Your ref: 3/2016/0886

Date: 10th October 2016

Planning Application 3/2016/0886: Re-sashing of plate glass windows to follow the original Georgian pattern; opening up dummy windows internally and fitting shutters and architraves to match existing; re-opening old doorways and closing existing; conversion of billiards room to family kitchen including removal of timber partitions, building up existing doorway and formation of two WC compartments and lavatory; formation of en-suite bathrooms to bedrooms including insertion of new partitions; refitting of former bathroom as laundry including restoration of mullioned window; removal of historic fabric for formation of central atrium; re-routing of service drive; Standen Hall, Worston Road, Clitheroe BB7 1PR.

Project: STANDEN HALL, CLITHEROE	
Drawing Title: SITE PLAN AS PROPOSED	
Scales: 1:200 @ A1	Date 13.ix.16
Drg. No. 2743/8	Revision: —

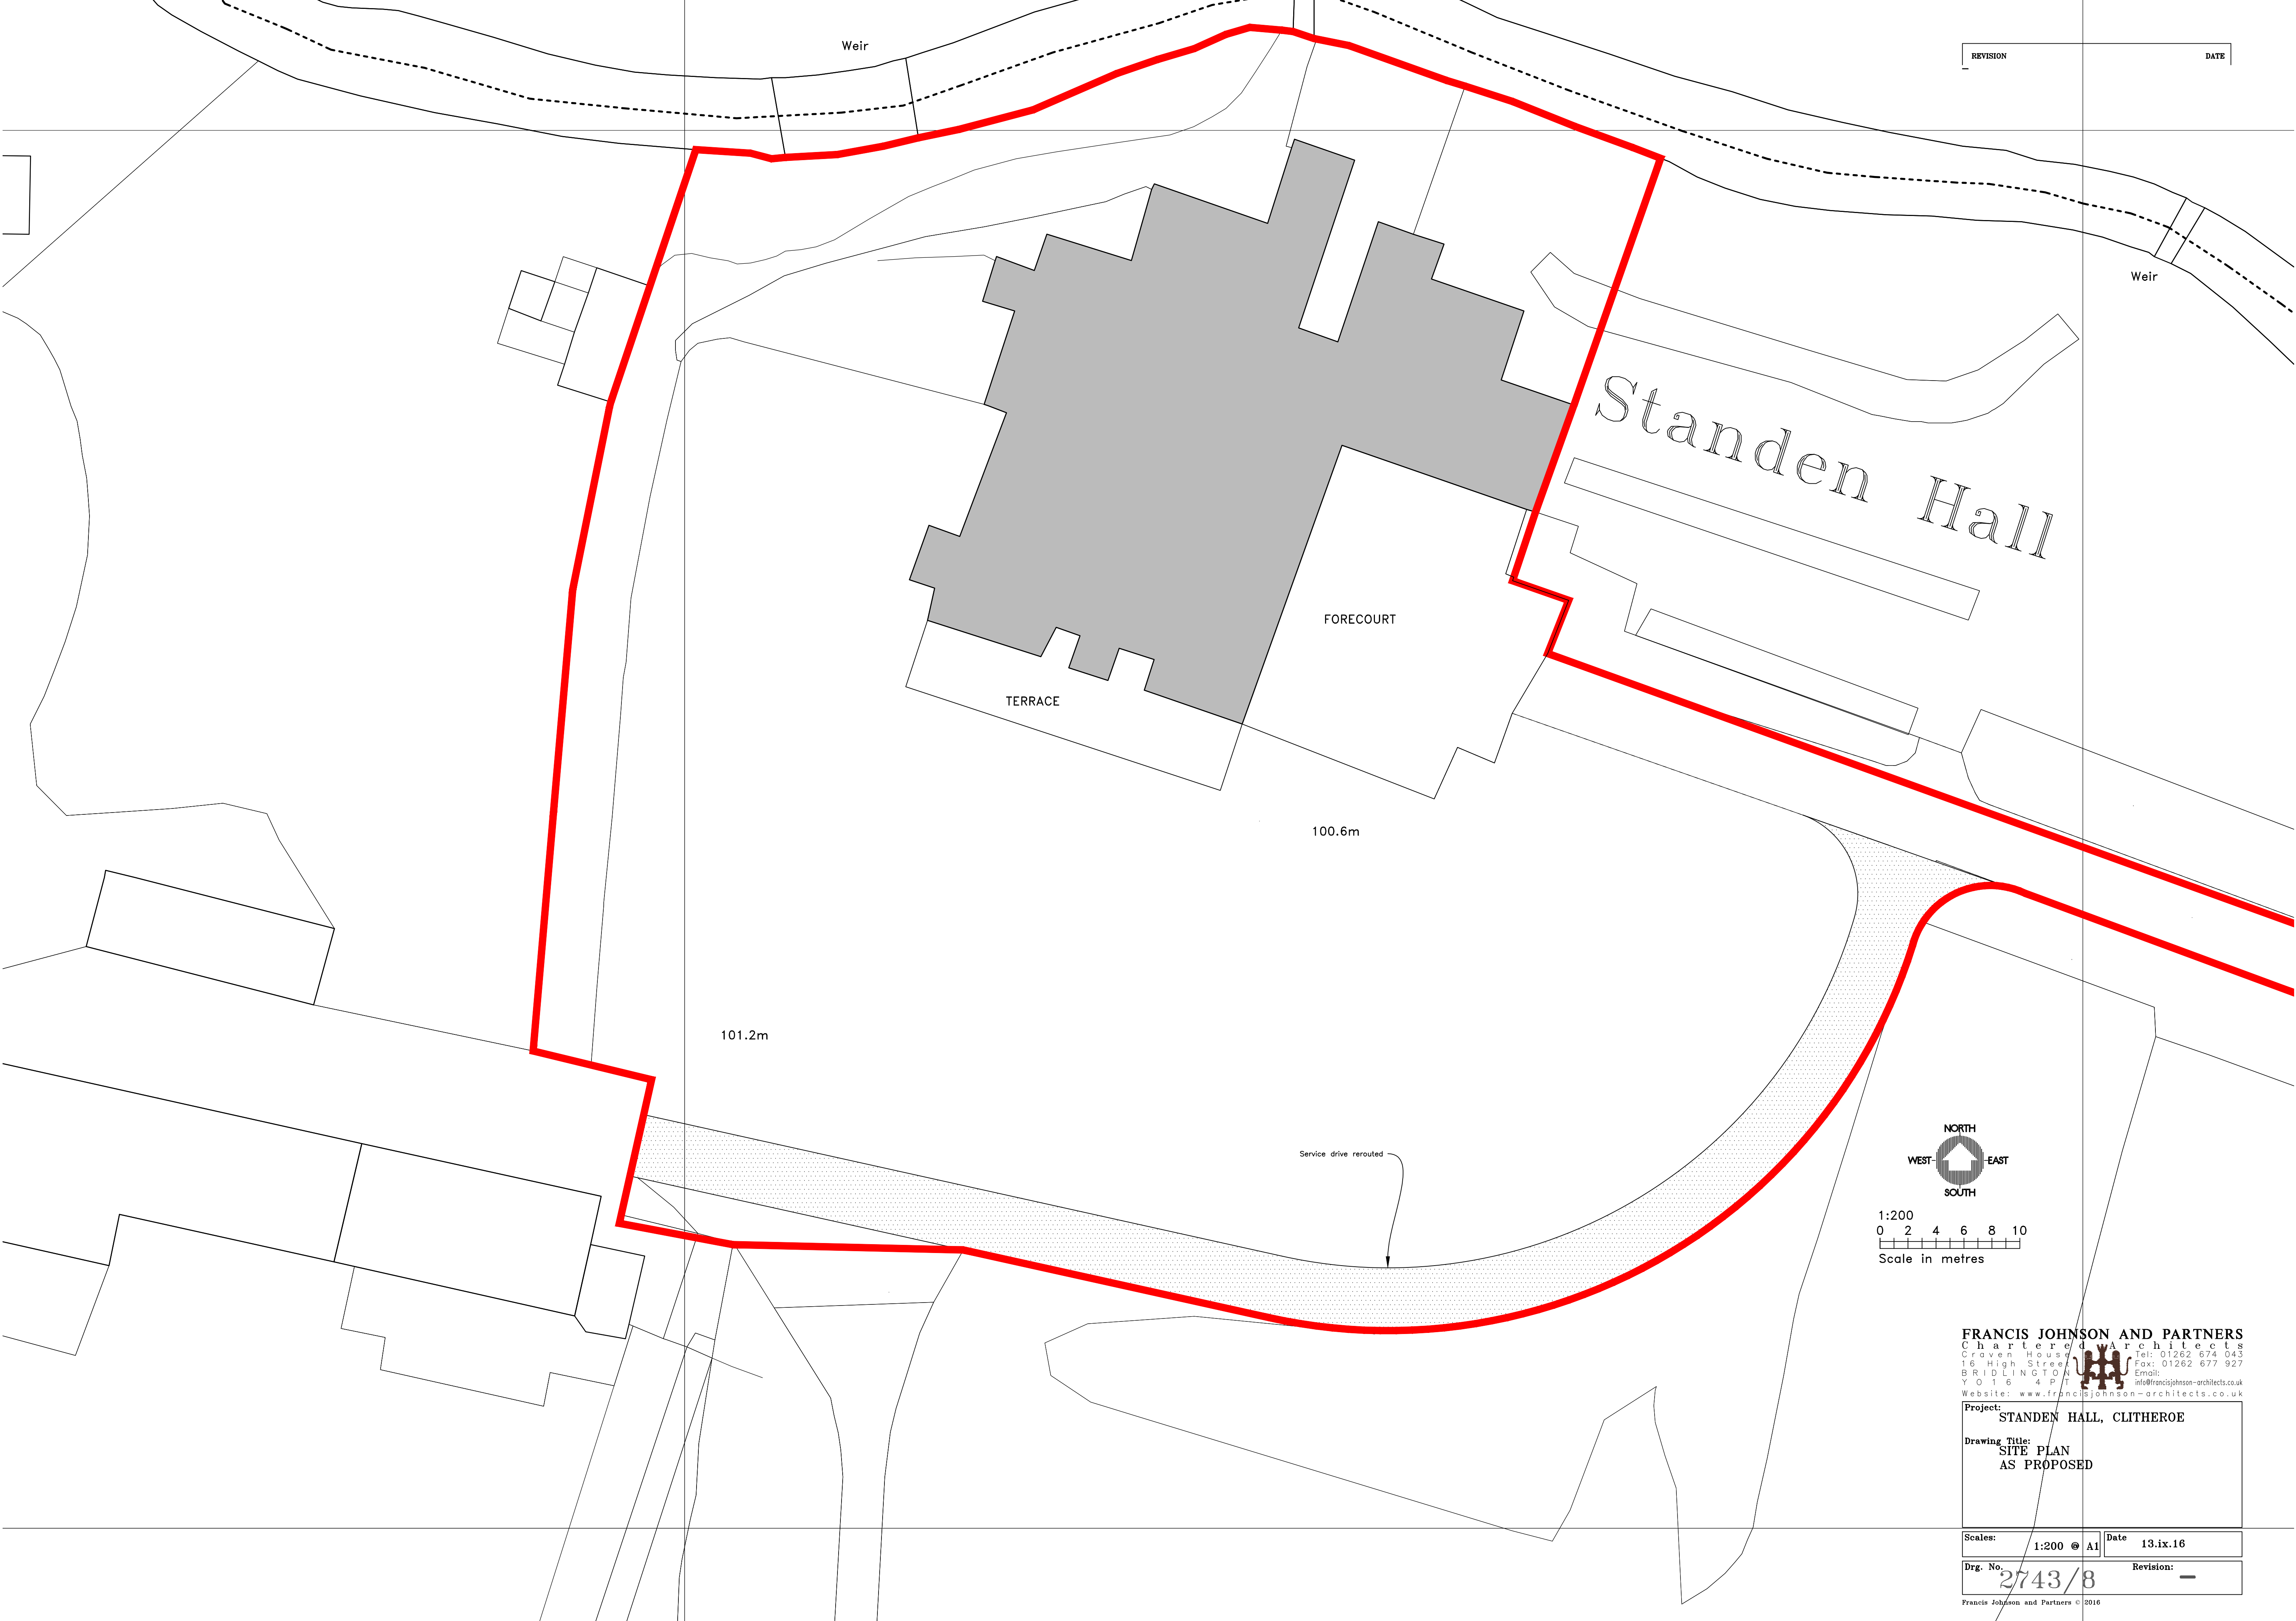
Finally it should be noted that the proposed alterations to the access to the service areas of the site (Design and Access Statement p.2 and drawing 2743/8) loops to the south of the main house and approaches the stable block through an area where a meandering garden part is shown on the OS 1:10,560 mapping of 1847-8 (sheets Lancashire 47 and 55, surveyed 1844-6) and the OS 1:2,500 maps of 1886 and 1893 (sheets Lancashire 47.14 and 55.02, surveyed 1884-92) before meeting the former line of the drive to the south of the hall. The latter mapping shows a fountain on the south lawn and the Listed mounting block (HE 1362348) is also located in this area. We would have no objection to the proposal in principal but would suggest that the applicants are asked how the proposals impact the mounting block (which is not noted in the DAS or shown on the plans), what is intended for it and how it will be protected during the works.
